RE: GATE OF HEAVEN CEMETERY AND MAUSOLEUM (D-19/D1A)  
ENGINEER'S STAMP DATED 11/21/94

# GATE OF HEAVEN CEMETERY AND MAUSOLEUM

## MASTER DRAINAGE AND GRADING PLAN

**Re: Gate of Heaven Cemetery  
Site Grading Plan  
Engineer's Stamp dated 6-9-12 (D19/D001A)**

PROJECT NUMBER 0702
DRAWN BY T.E/SEJ
CHECKED BY KRB
ISSUE DATE 1-9-12
FILE NAME: 0702_C-103_SITE GRADING PLAN
SHEET NAME
SITE GRADING PLAN
SHEET NUMBER
C-103

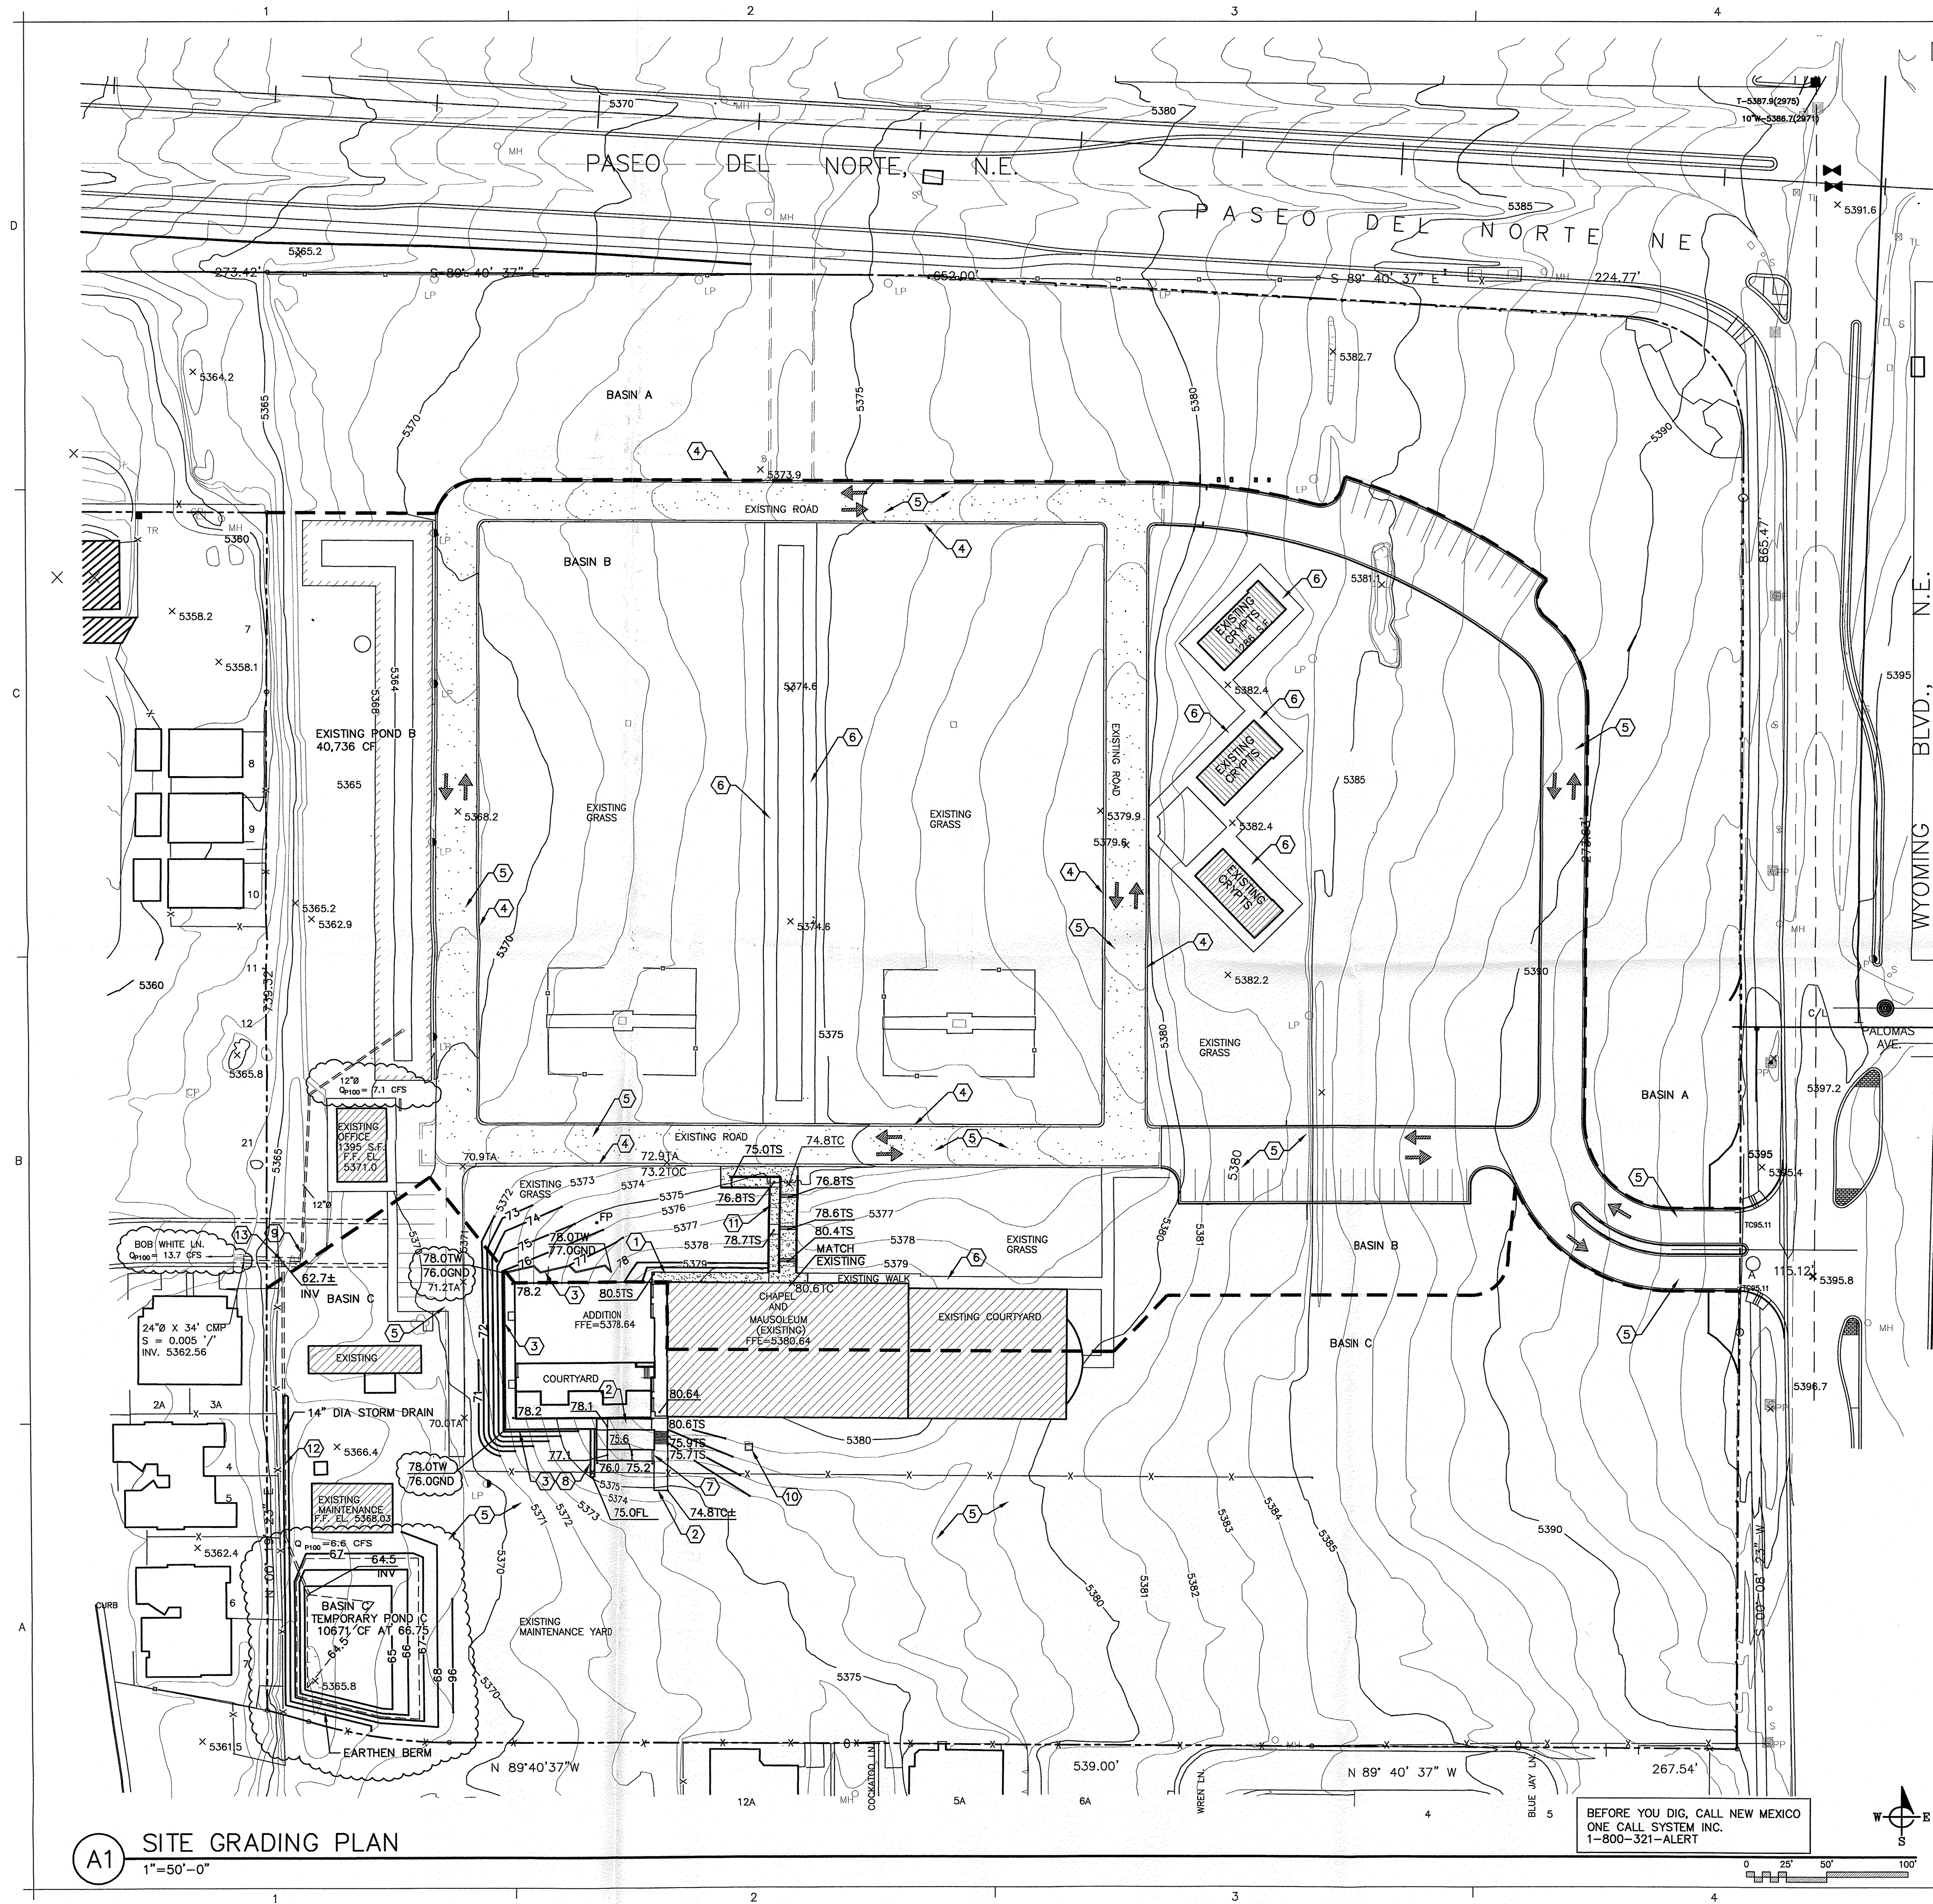
- Per approved grading plans dated 6/4/2002 and 11/21/94 basins B & C were to drain into ponds B & C which was then piped to the outfall at Bob White Lane at a rate of 13.7cfs. This plan should propose the same drainage scheme.
- Provide basin, pipe and pond calculations to support the above mentioned drainage scheme.
